Shivesh Singh - Scottish Hospital - Paddington Society submission

THE PADDINGTON SOCIETY Inc.
For Community and Heritage
Est 1964

16th December, 2010

Scottish Hospital Redevelopment - MP10_0016 Part 3A
2 Cooper Street Paddington

Proposed Shadows - 21st June 1.30pm

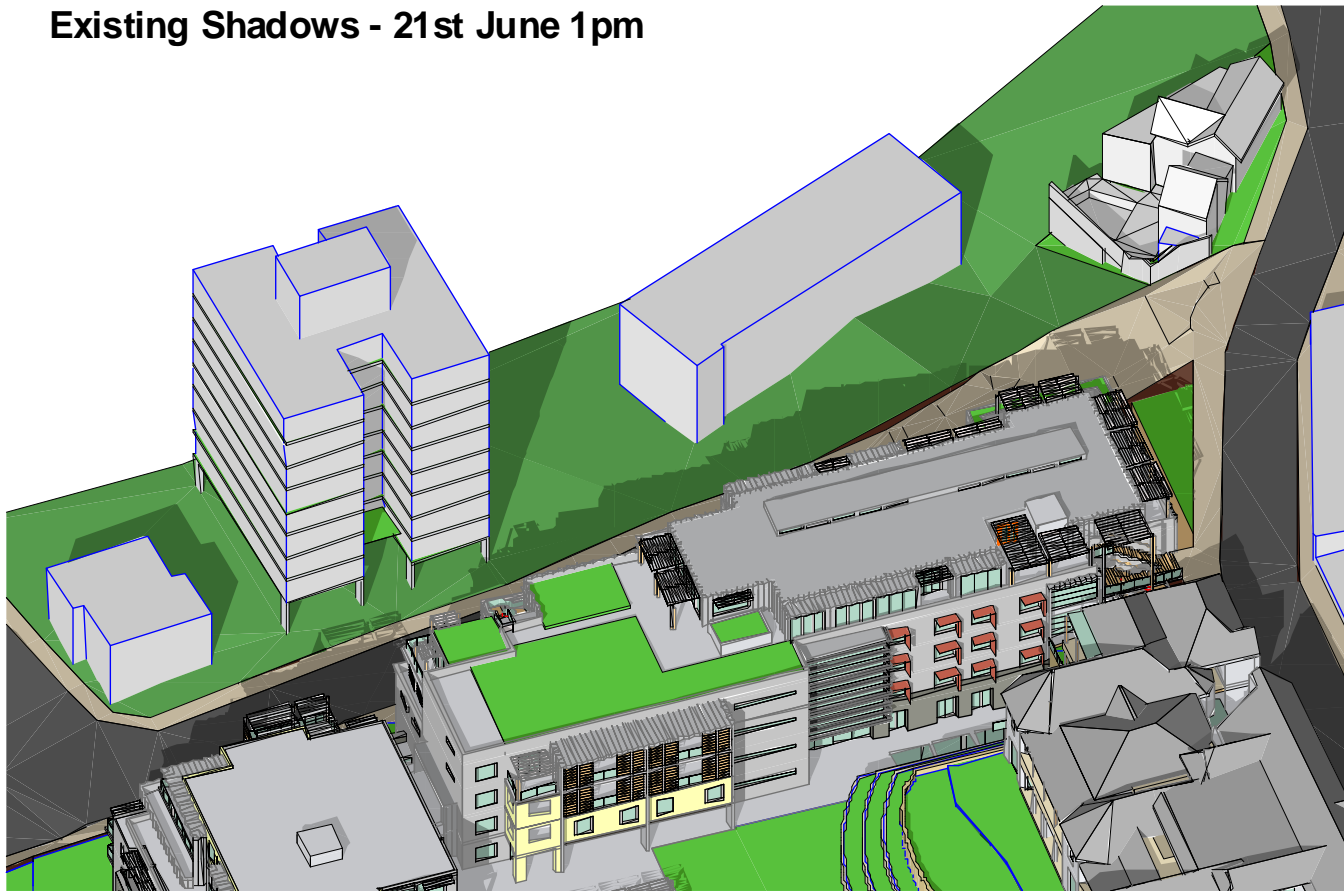
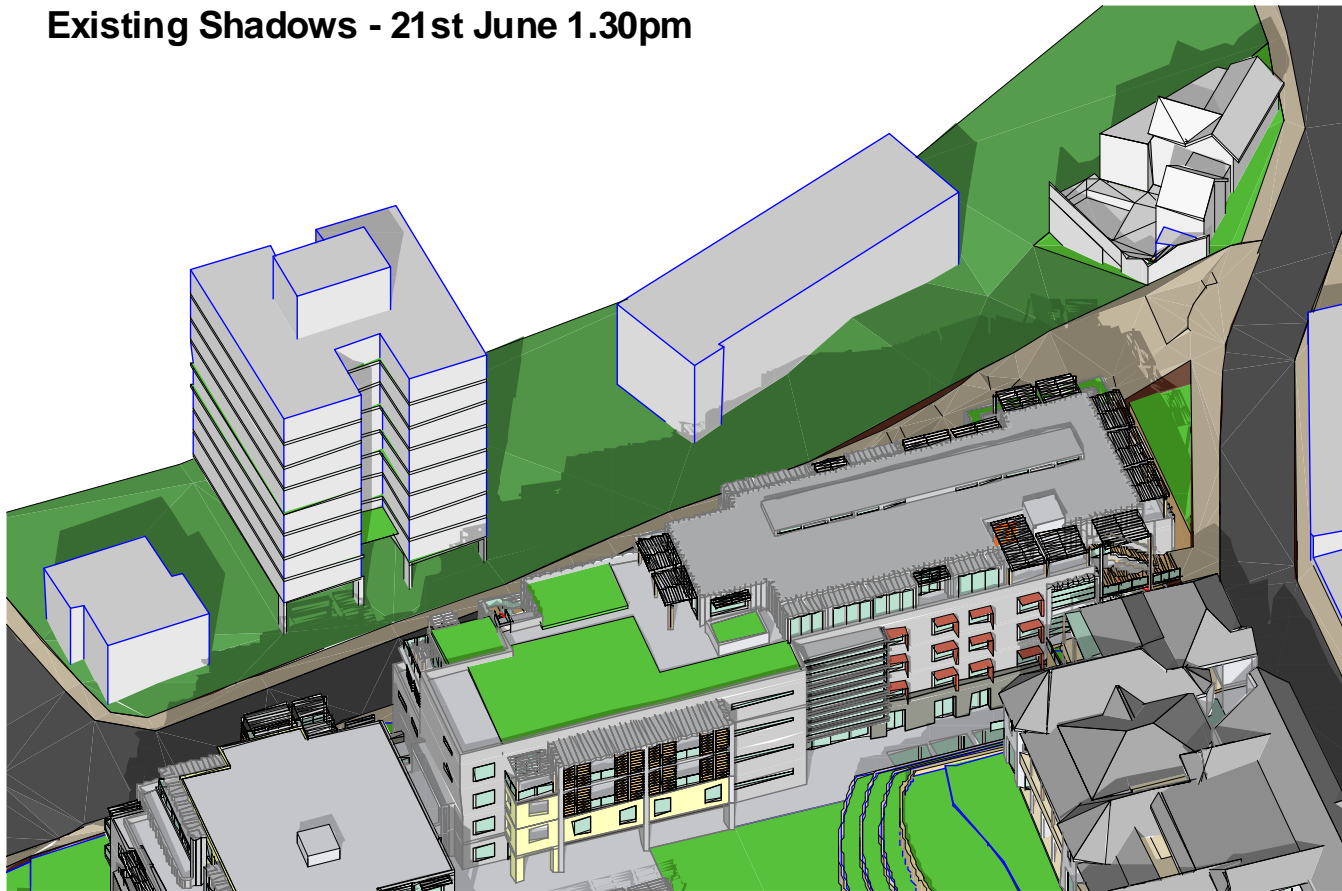
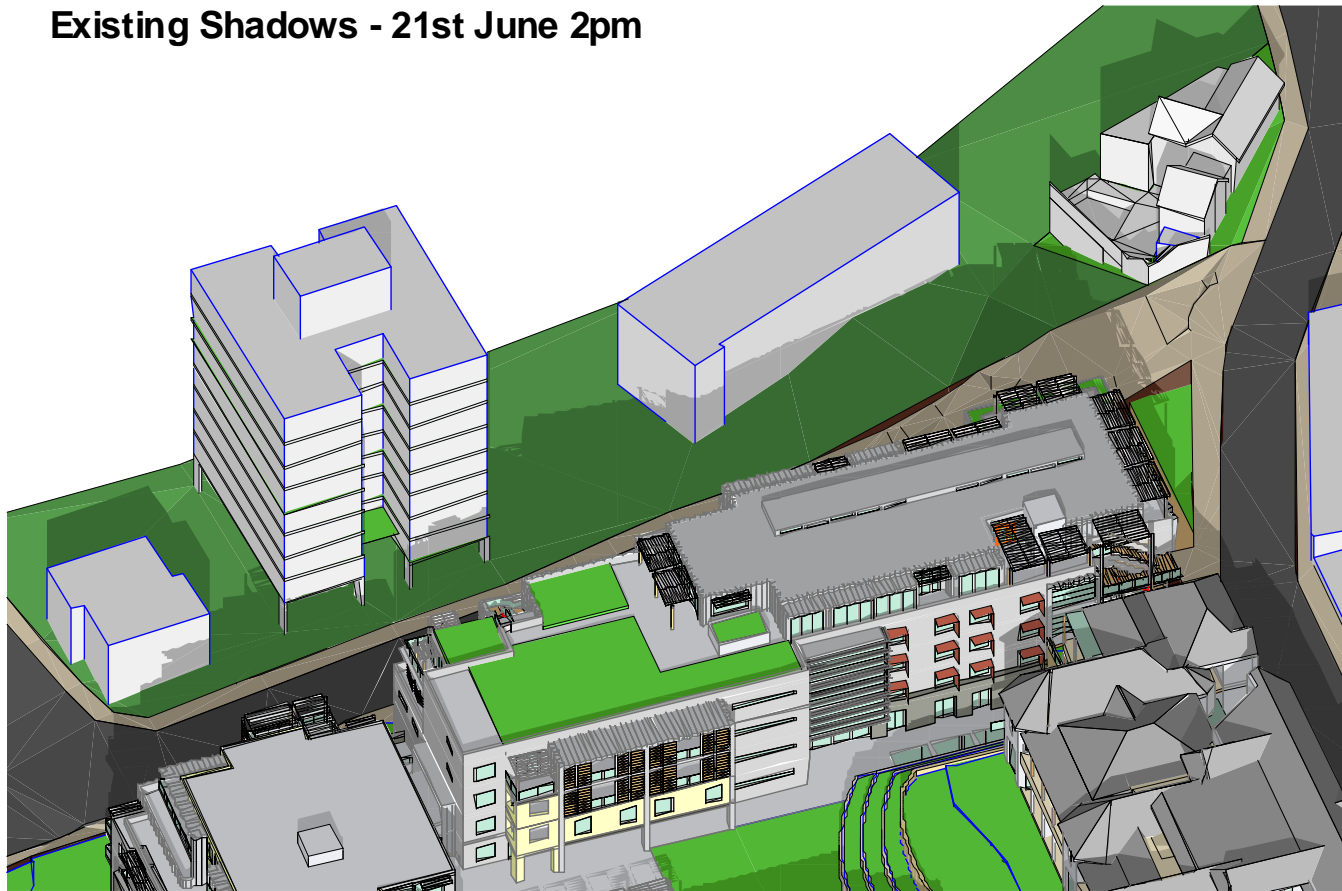
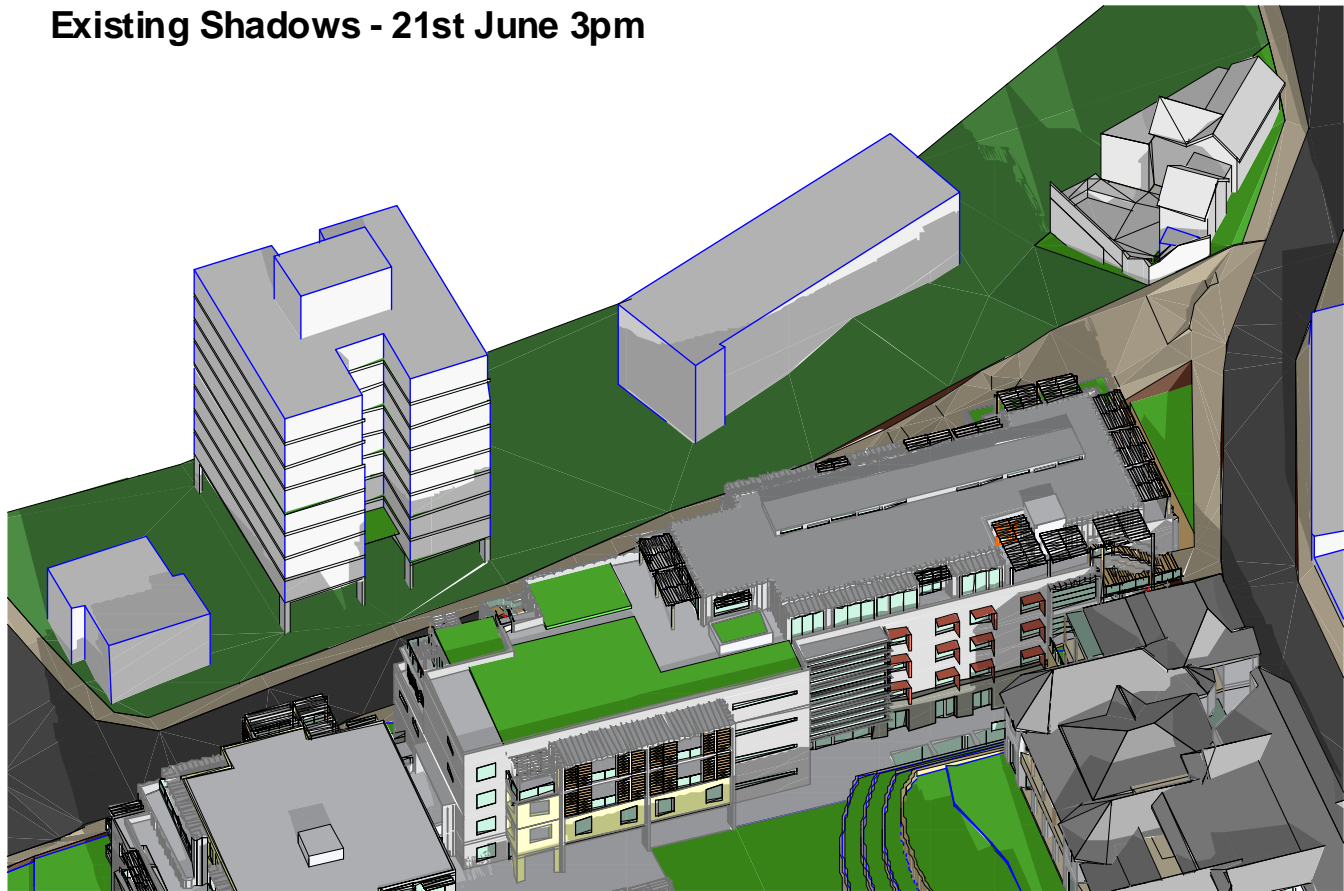
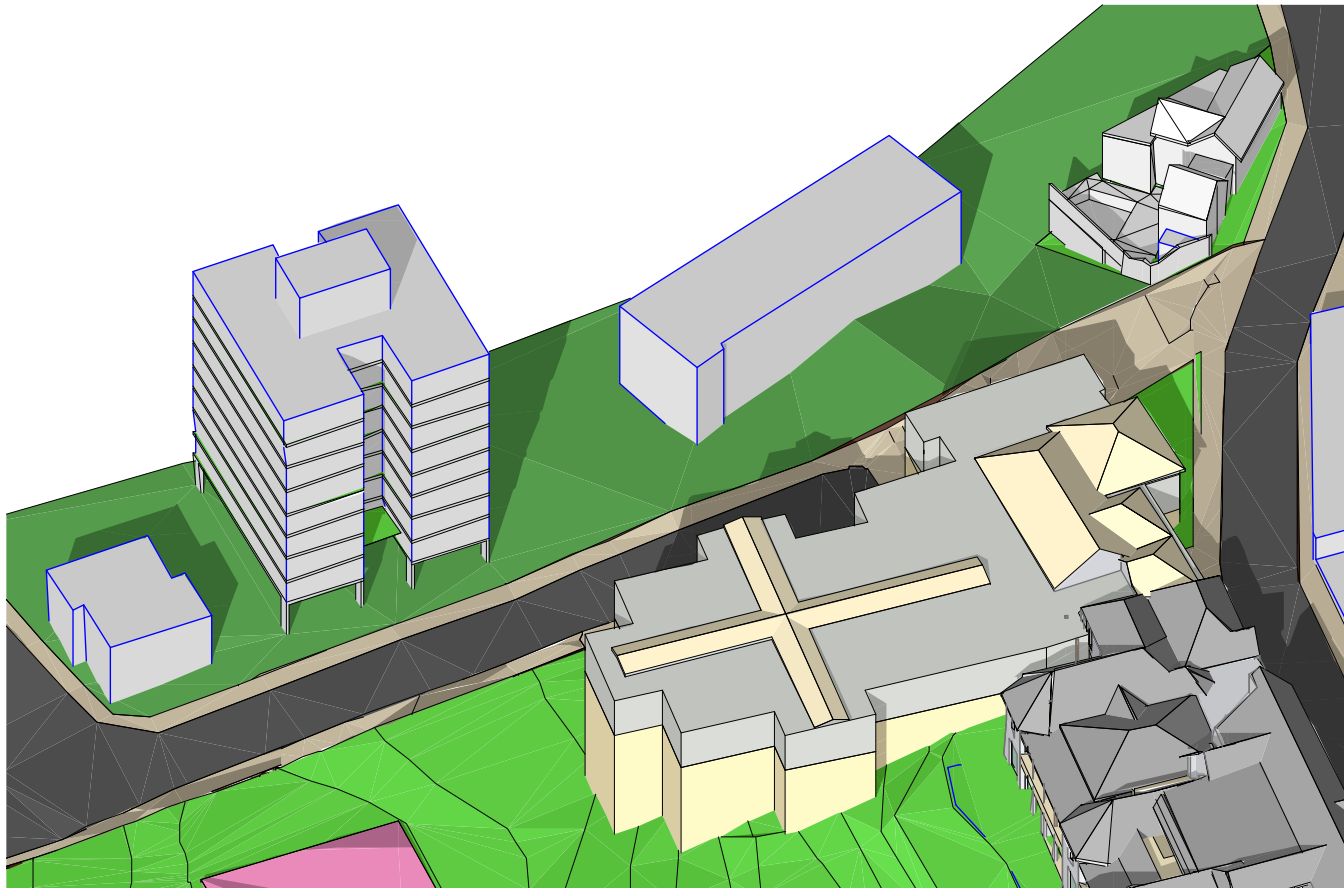
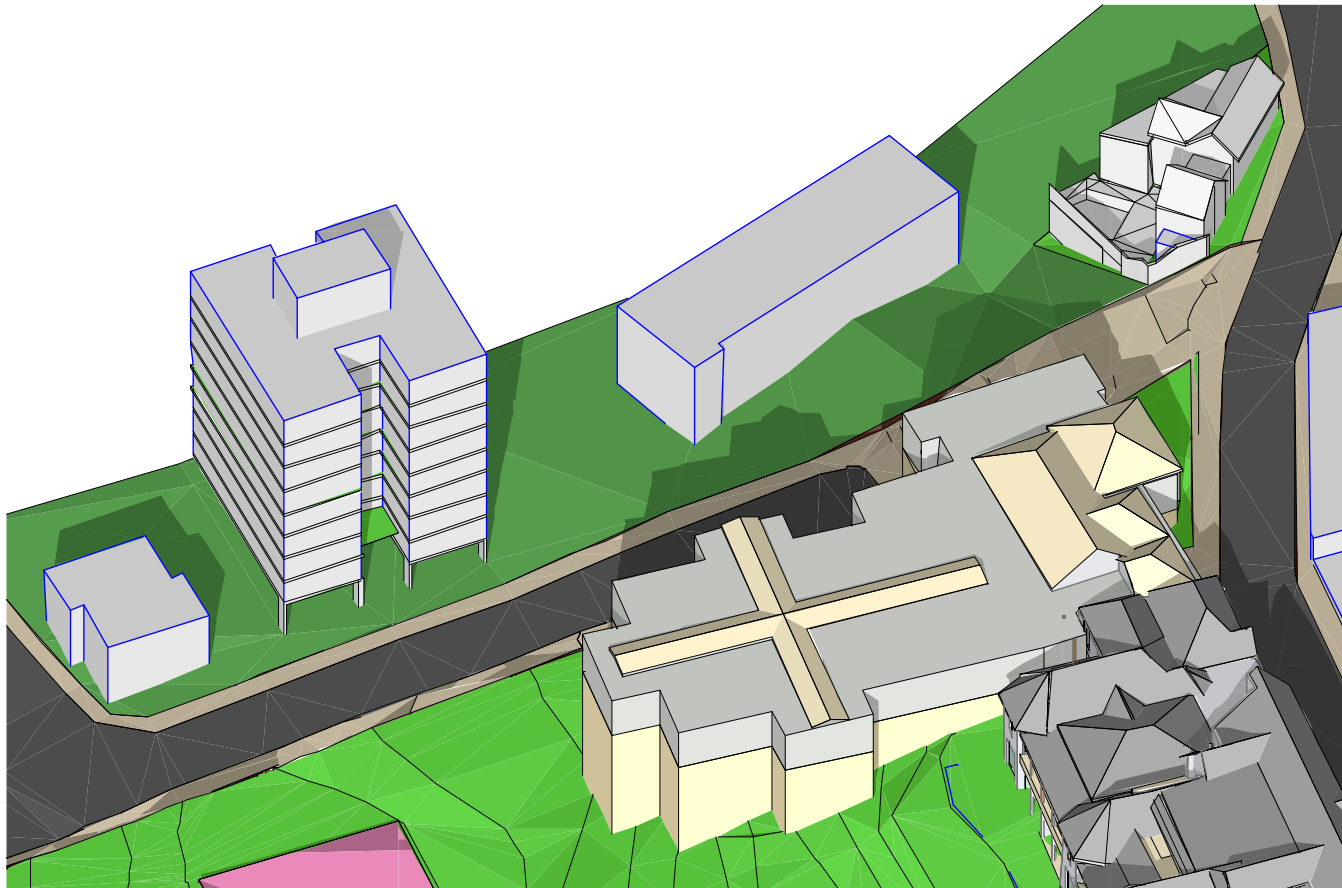
It would appear that the buildings along Stephen Street will take all winter sun from 42 Stephen Street by 1.30pm and parts of 38 Stephen Street.
